Planning Application Ref: F/18/19/PL

Location: Land adjacent to 3 Wicks Farm Cottages, Ford Lane, Ford, BN18 0DQ

Description of works: 1no. new dwelling. This application is a Departure from the Development Plan

Block plan 1:500

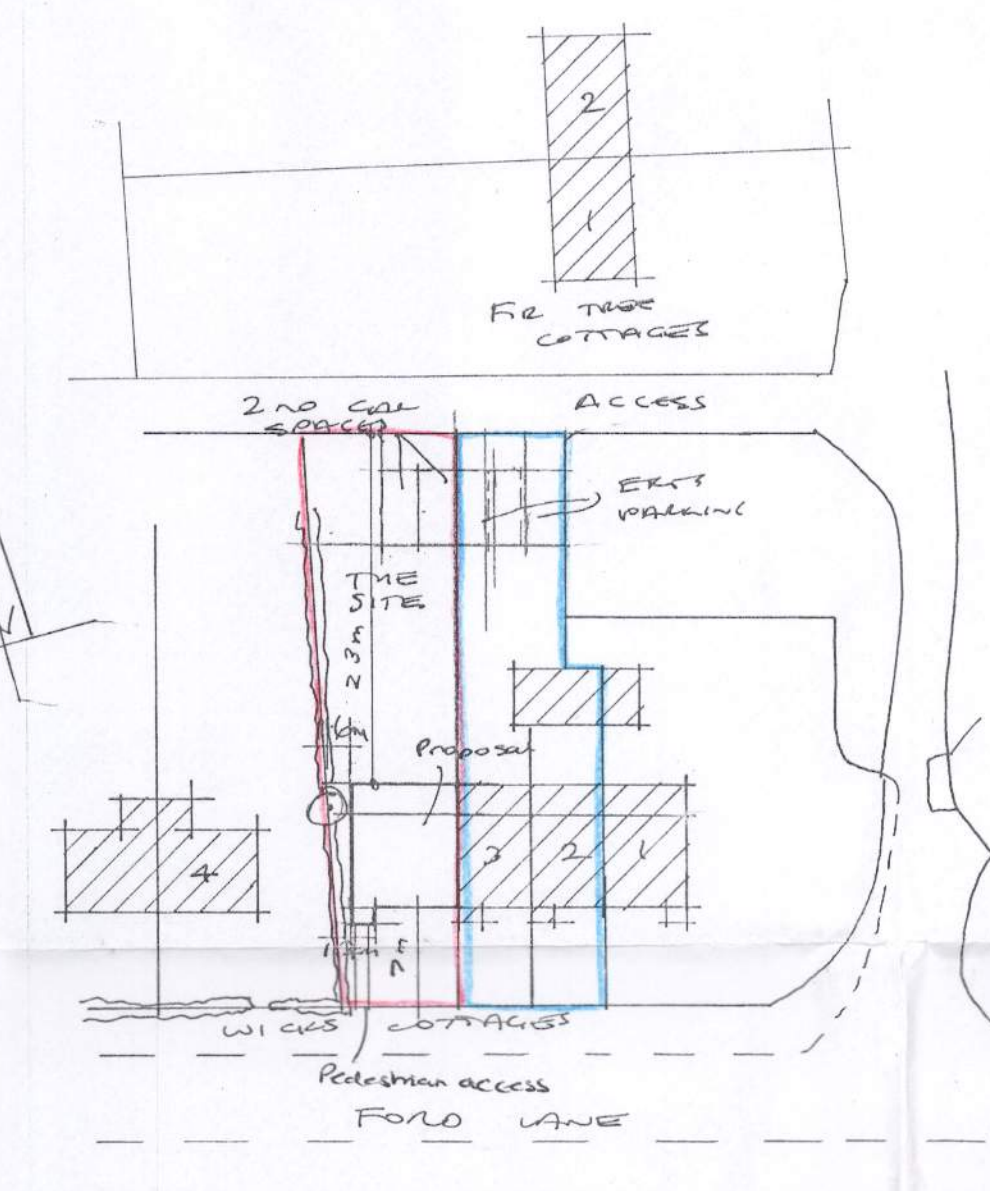
- There appear to be on and off-site trees and hedgerow both along and straddling the boundary between numbers three and four Wicks Farm Cottages. They could be adversely affected by these proposals. There is very little supporting arboricultural information submitted with the application. As such, were this application to now proceed, we will not have sufficient information to guarantee such trees and hedgerow would be adequately respected and protected.
- The applicant has submitted their own Arboricultural Method Statement which while well-intentioned and promotes good practice, does not meet the requirements of BS5837:2012 – *Trees in relation to design, demolition and construction*, and is not adequate for this project.

1. The applicants will need to employ the services of an Arboricultural Consultant to carry out a tree survey exercise and then prepare an Arboricultural Impact Assessment (AIA) which must be inclusive of; a 'Tree Survey Schedule', a 'Root Protection Area (RPA) Schedule' – with the trees accurately plotted on a topographical plan.

2. In the event that a RPA of any tree which is proposed for retention overlaps the development then BS5837:2012 requires that the Detailed Planning Application is accompanied by an Arboricultural Method Statement (AMS) and also most importantly a Tree Protection Plan – to both describe and illustrate the mitigation measures which are to be employed to ensure that the trees survive without detriment to their vigour and vitality and are given adequate protection both above and below ground.
